WELWYN HATFIELD COUNCIL – DEVELOPMENT CONTROL
DELEGATED REPORT

APPLICATION No:	S6/2008/102/FP
------------------------	-----------------------

This is a retrospective application for the installation of an aluminium framed shopfront powder coated in RAL 7015 with an electronic perforated lath type shutters powder coated in RAL 7015 and a sliding glass door at the Sella Supermarket, unit 7, Parkhouse Court, Hatfield District Centre.

BALA
UNITS 6&7
COMET SQUARE
HATFIELD
HERTFORDSHIRE

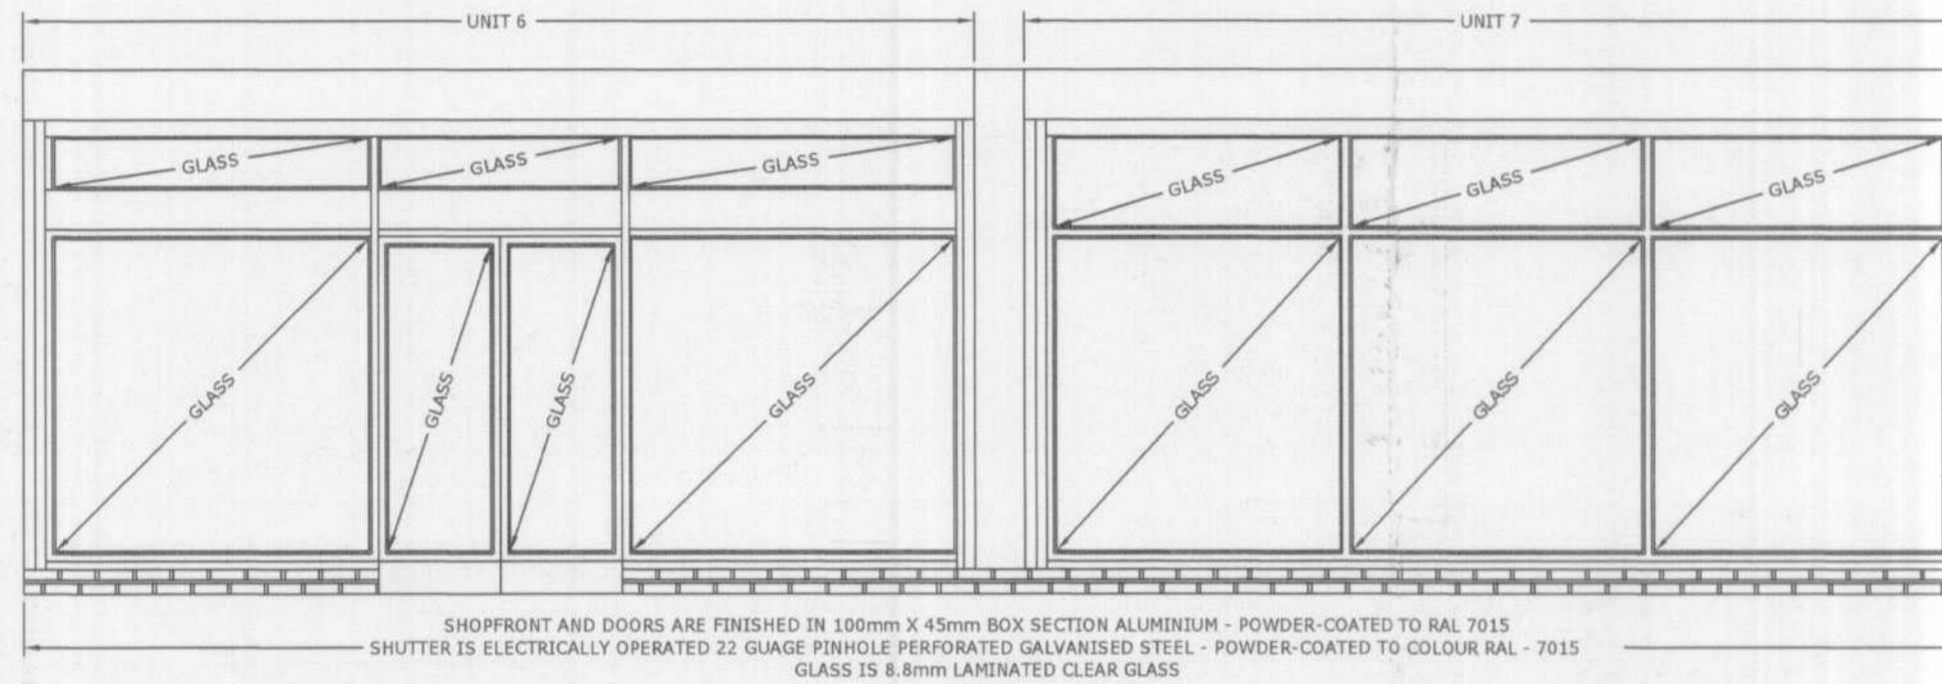
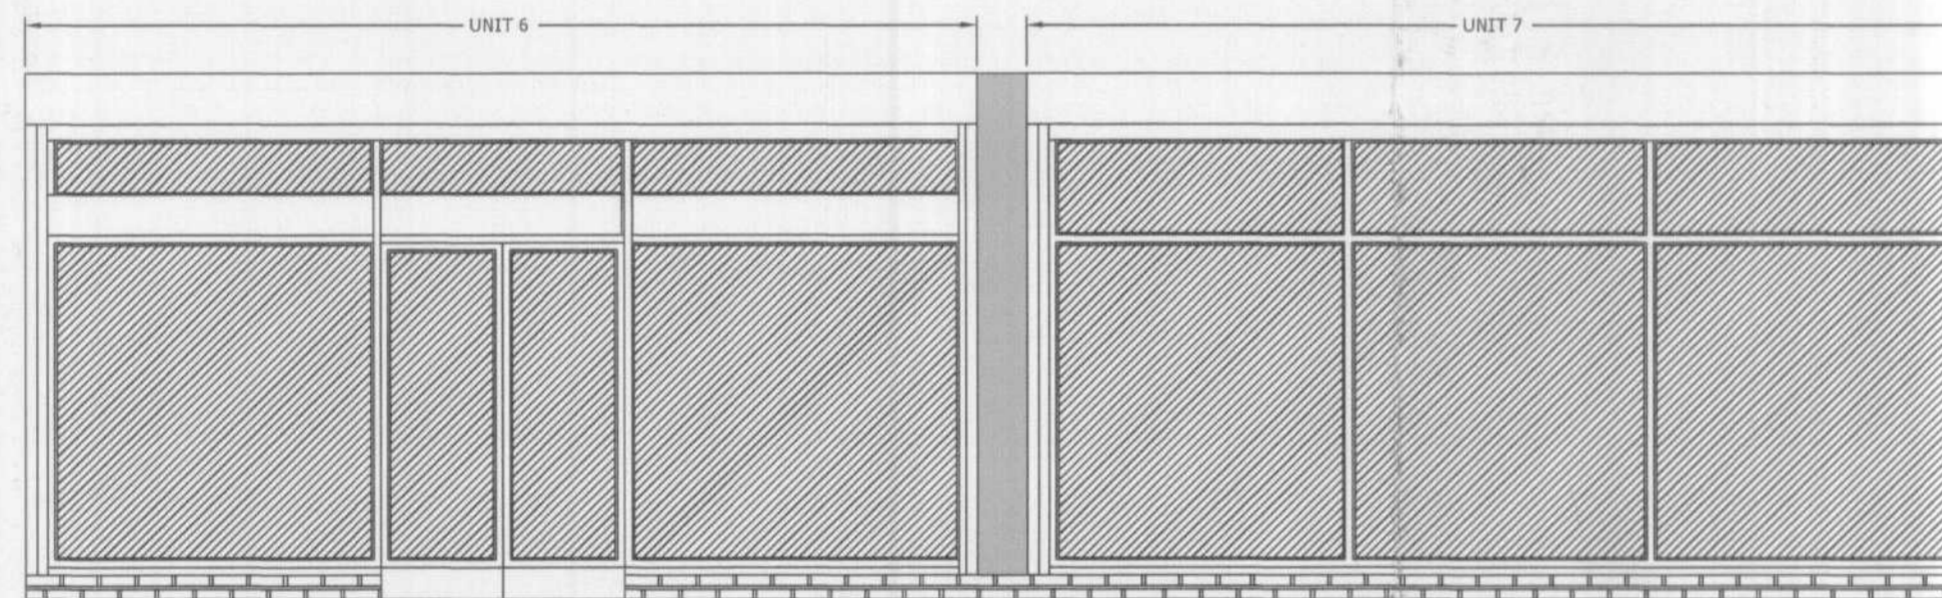
The shutters that have been installed at this unit are perforated lath shutters. Whilst these shutters are not the Local Planning Authorities preferred security measure the Supplementary Design Guidance SPD states that they can be used if the unit is kept illuminated during hours of darkness. This is to allow for the natural surveillance of the unit by members of the public (as they will be able to see into the unit) and to aid in the creation of a sense of openness in the District centre, whilst helping to promote the image of a modern shopping area.

The level of natural surveillance into unit 7 is however limited due to the fact that shelving has been erected across the inside of the right hand side of the shopfront meaning that no-one can see into this side of the shop. In addition to this some shelving has also been erected on the left hand side of the unit thus reducing visibility into the unit even more. The fact that visibility into this unit is restricted detracts from the overall appearance of the District Centre, as it is not in keeping with the modern image we are keen to promote. In addition to this it does not contribute to the creation of a secure environment especially at night. Given this we have attached a number of conditions to this approval relating to the use of the installed security shutters in the interest of enhancing security and protecting residential amenity in the District Centre.

The shopfront has been designed to allow for easy access to the store for disabled people as it has a wide entrance and a sliding door. The proposal therefore accords with Policy D5 which requires all new development to take account of its impact on existing and proposed movement patterns and Policy D9 which requires that all new development should be designed to allow access by the disabled, young children in prams and pushchairs and those who are temporarily disabled through accident and injury.

1. The unit is required to be internally illuminated when the shutters are down.

2. Visibility into the whole of the unit shall be maintained at all times.

3. The unit shall at all times maintain a window display across the full width of the unit facing onto Parkhouse Court.
